**Planning Department
Transportation Development Services**

October 12, 2015

**Re: A Façade Renovation
111 Cardenas NE
Traffic Circulation Layout**
Engineer's/Architect's Stamp dated 10-9-15 (K18-D106)

VICINITY MAP  
NOT TO SCALE

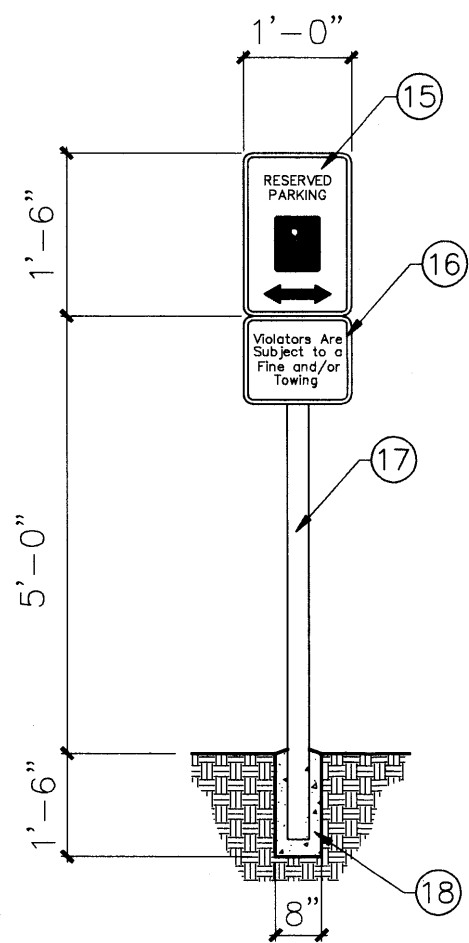
1. Please show a vicinity map showing the location of the development in relation to streets and well known landmarks.
2. List the number of parking spaces required by the zoning code, as well as the proposed number of parking spaces.

TRAFFIC CIRCULATION PLAN 111 CARDENAS DR NE  
1/16" = 1'-0"

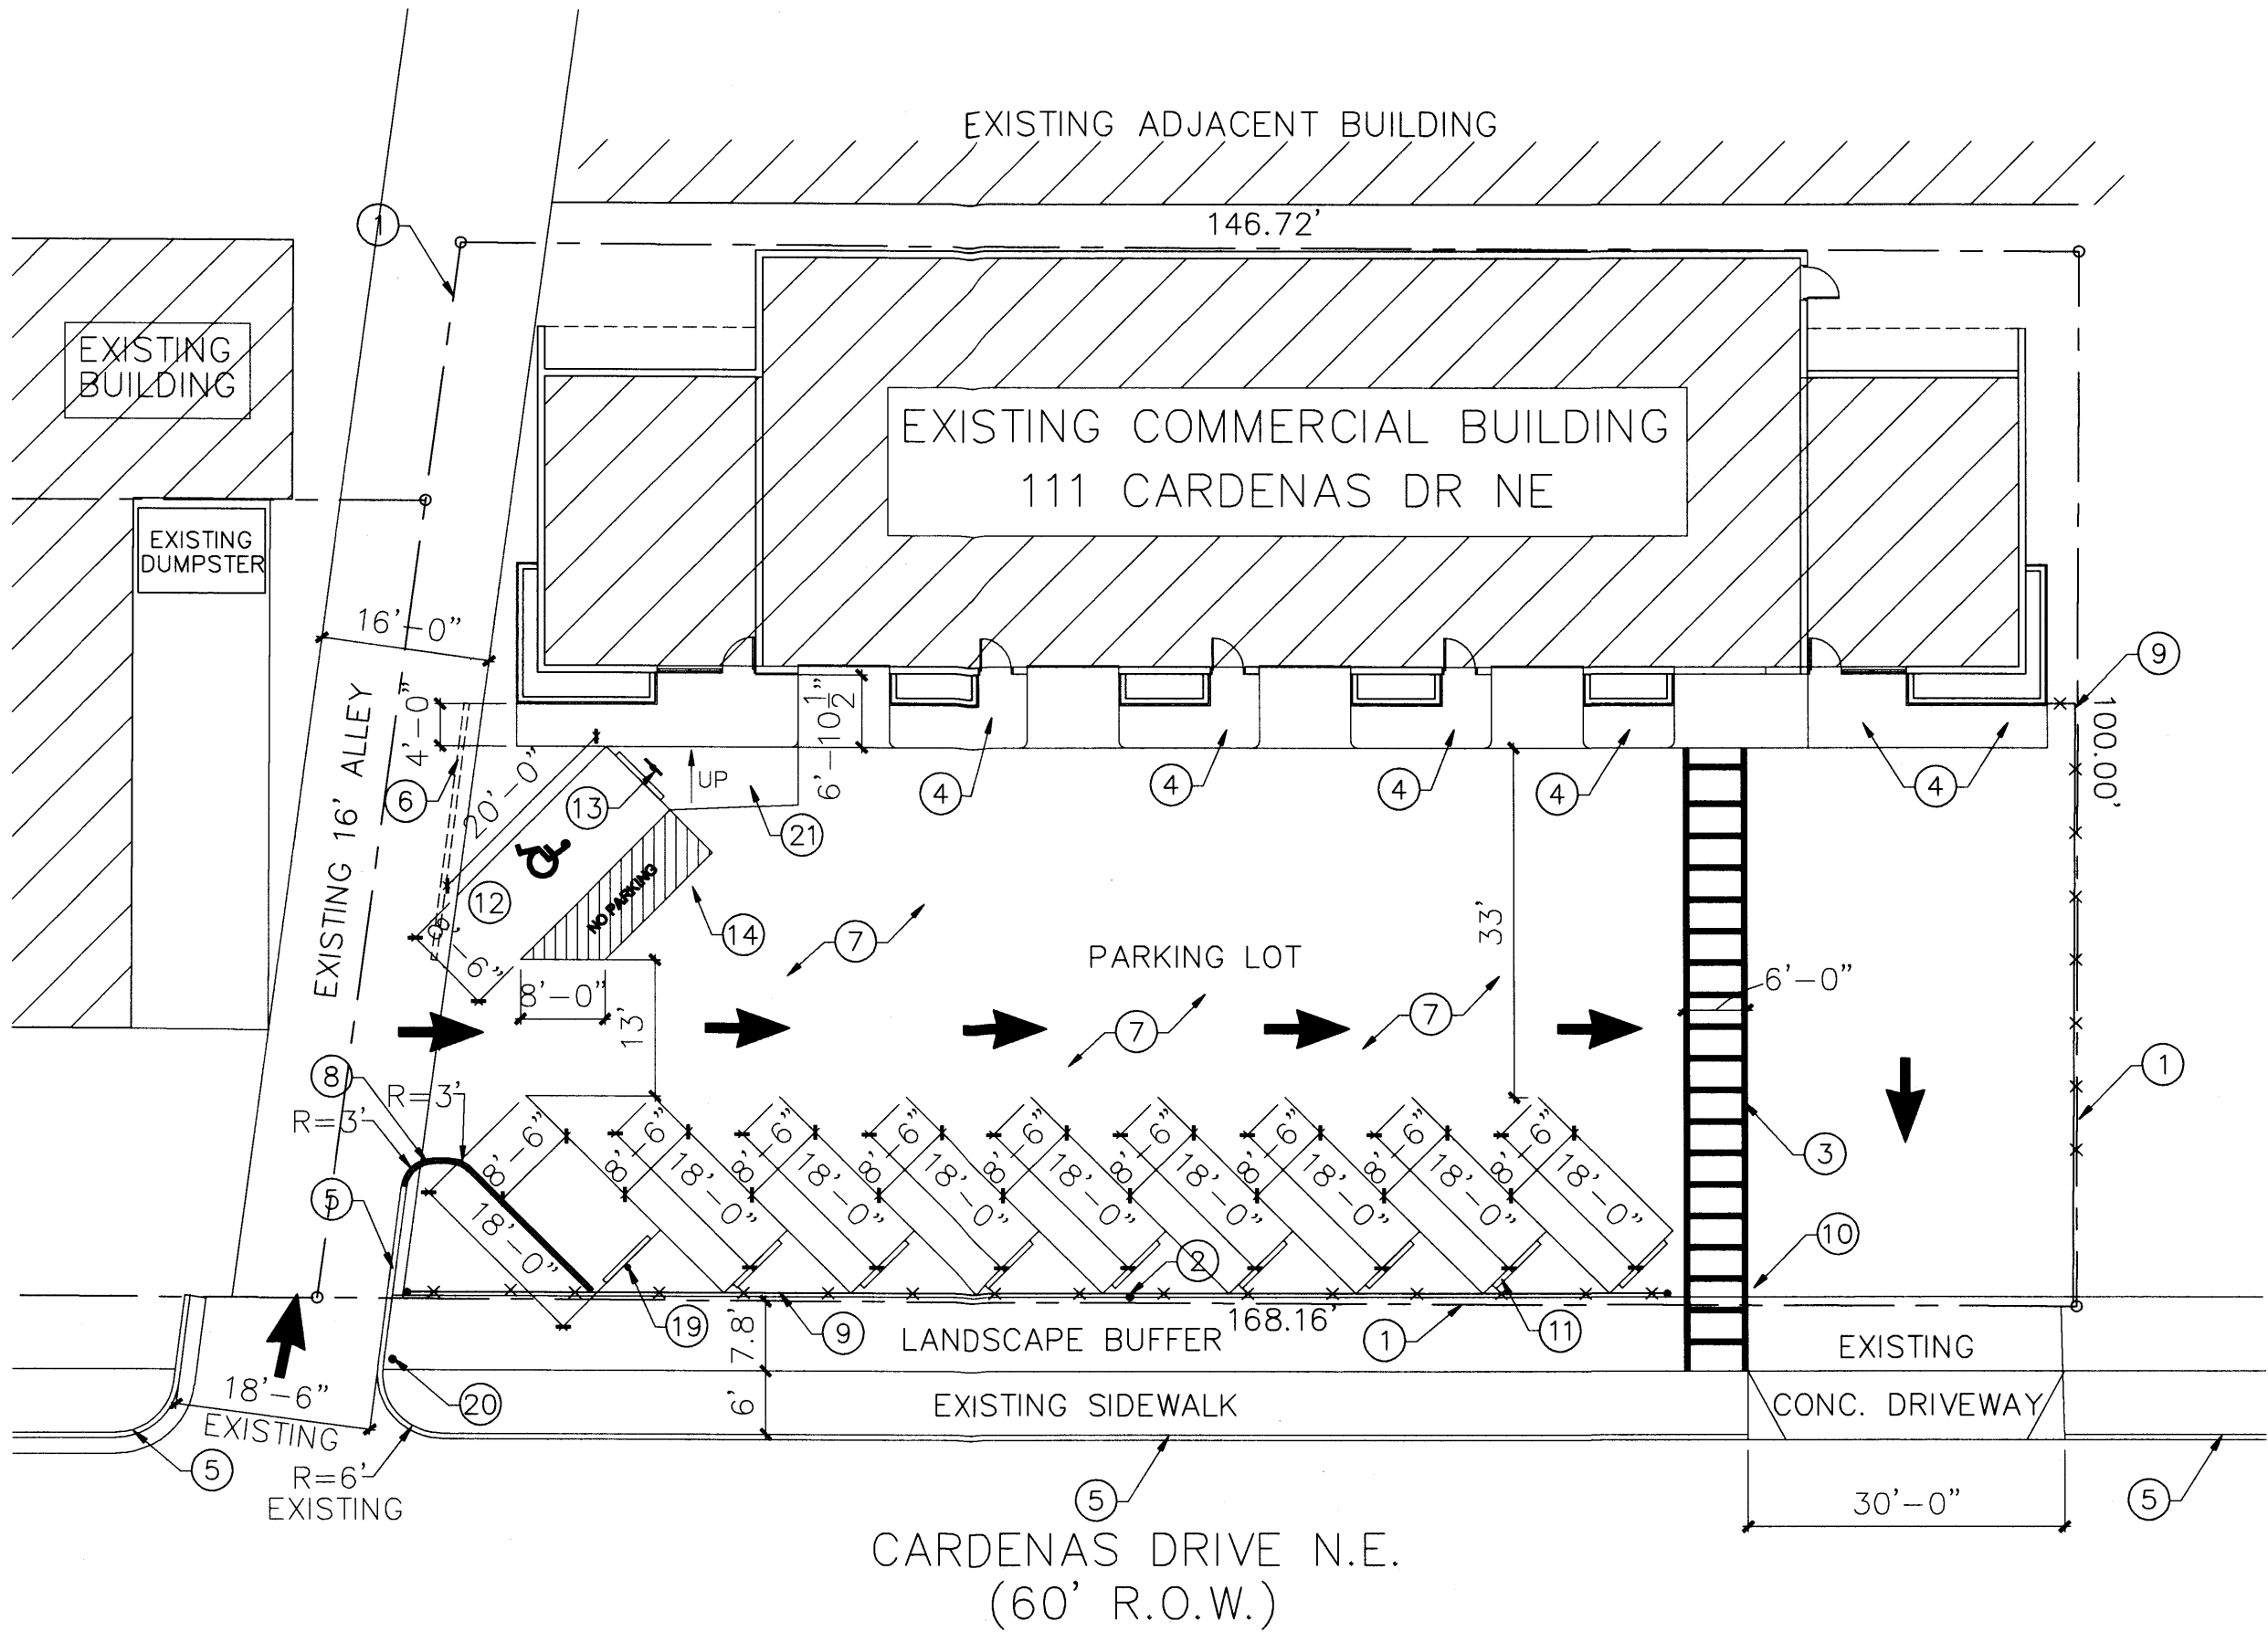
3. Clarify the extents of the current phase.
4. Please identify all existing electrical and light poles that influence the parking and circulation on the site.

5. Identify all existing access easements and rights of way with dimensions.
6. Identify the right of way width, medians, curb cuts, and street widths on Cardenas Dr.

7. Please list the width and length for all parking spaces. Identify the distance between all angled parking spaces. Per DPM, there must be an 11 ft. drive isle between angled parking spaces.

10. Show all drive aisle widths and radii.

11. List radii for all curves shown; for passenger vehicles, the minimum end island radius is 15 feet. Landscape island radius for delivery trucks, fire trucks, etc. is 25 feet or larger

12. Per the DPM, a 6 ft. wide ADA accessible pedestrian pathway is required from the public sidewalk to the building entrances. Please clearly show this pathway and provide details.

13. Per the DPM, a 6 ft. wide ADA accessible pedestrian pathway is required from the HC parking stall access aisles to the building entrances. Please clearly show this pathway and provide details.

14. Provide a min 6" or max 8" high concrete barrier curb or other acceptable barrier between landscaping and parking areas and/or drive aisles.
15. Design delivery vehicle route needs to be shown.

16. Service vehicle and/or refuse vehicle maneuvering must be contained on-site; provide a copy of refuse approval.
17. It is not apparent what type of pavement surface is being proposed. A hard driving surface will be required as part of this proposed project for parking area and drive aisles. The drawing states that there is "existing earth", please clarify detail.

22. Unused curb cuts must be replaced with sidewalk and curb & gutter. A build note must be provided referring to the appropriate City Standard drawing.
23. Please include two copies of the traffic circulation layout at the next submittal.

2 CLEAR SITE TRIANGLE @ INTERSECTIONS  
C1 NOT TO SCALE

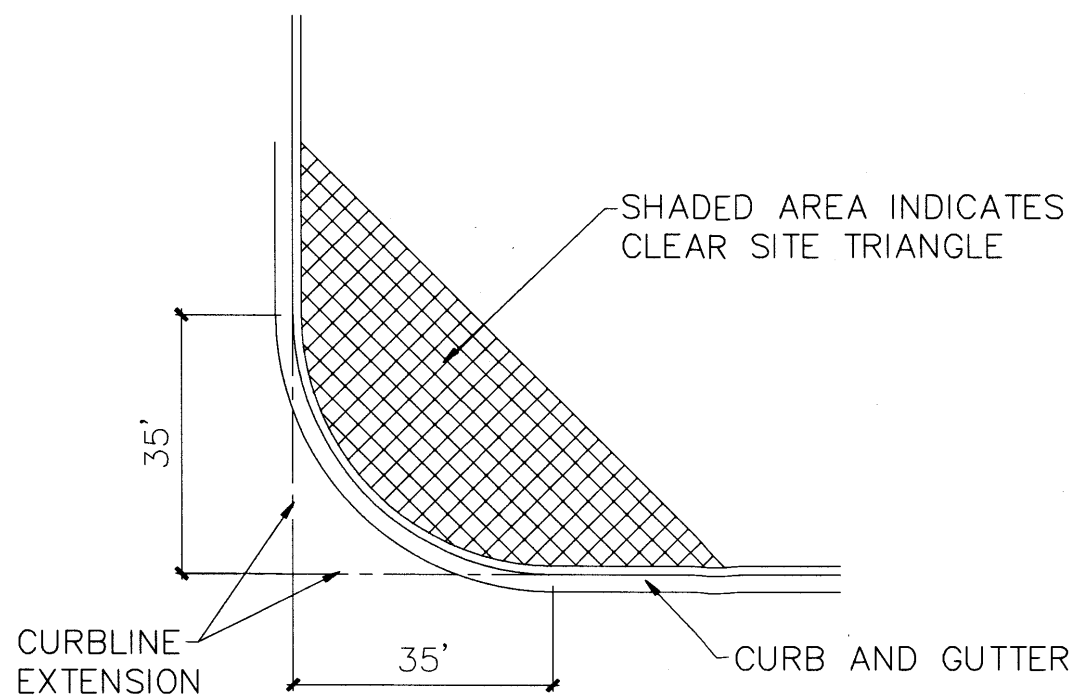
18. Please clarify how the site meets clear sight triangle requirements.
19. Please provide a sight distance exhibit (see the *Development Process Manual, Chapter 23, Section 3, Part D.5 Intersection Sight Distance*). Please provide this detail on Cardenas Dr.

20. Please add the following note to the clear sight triangle: "Landscaping and signage will not interfere with clear sight requirements. Therefore, signs, walls, trees, and shrubbery between 3 and 8 feet tall (as measured from the gutter pan) will not be acceptable in this area."
21. Please include a copy of your shared access agreement with the adjacent property owner.
